KITITITAS COUNTY COMMUNITY DEVELOPMENT SERVICES

Re: The Grove

After reviewing the plans for The Grove development, I have the following comments/conditions:

Revised site Plan July 7, 2006

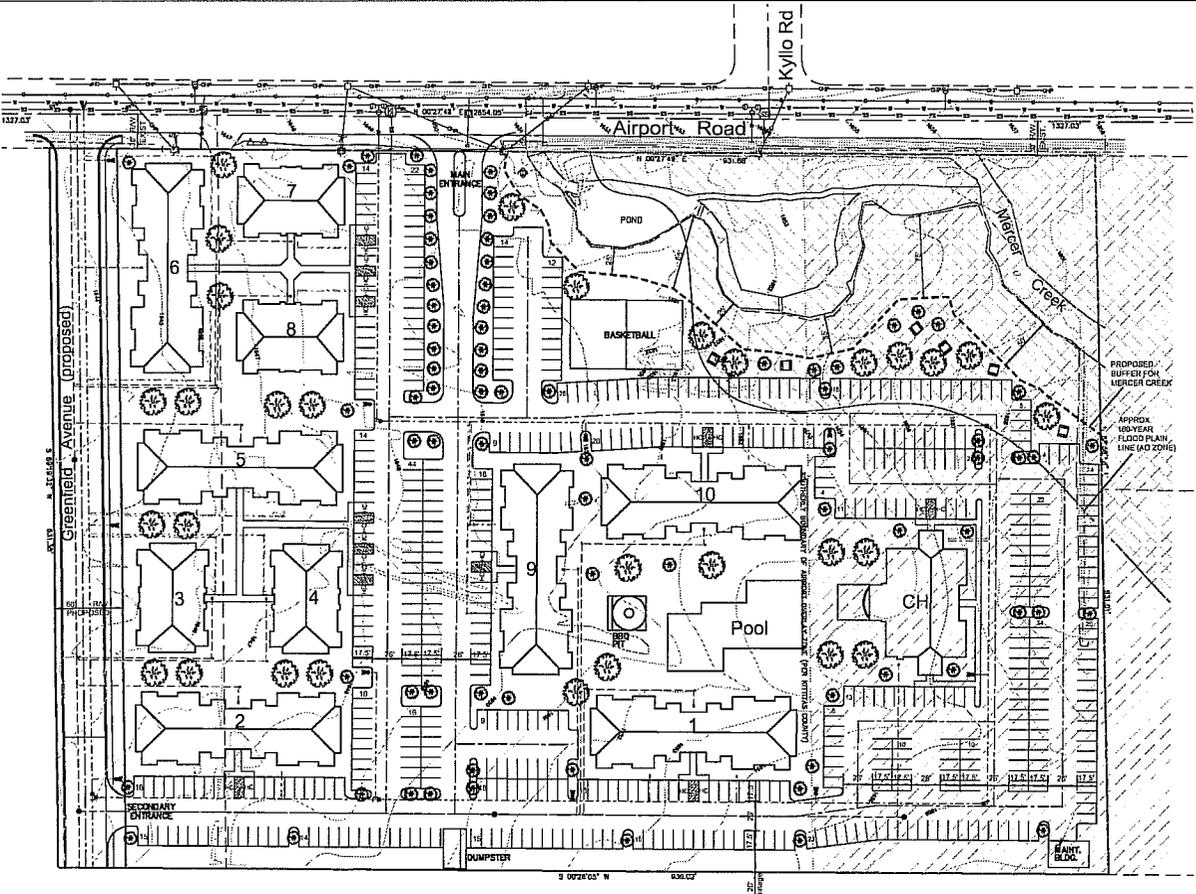
- The FDC's shall be located at the front of each building facing fire department access unless otherwise approved by the City of Ellensburg Fire Marshal. Any remotely located FDCs shall be approved by the City of Ellensburg Fire Marshal.

- Horn strobes are required to be facing fire department access on buildings 7, 9 and 4.
- The Knox Box keyed/keyless entry shall be located on the left side of the electrically gated area.

- Ensure there are no obstructions to fire department access from the general parking area to building 7.
- Site plan schematic showing addressing must be posted at both entrances.
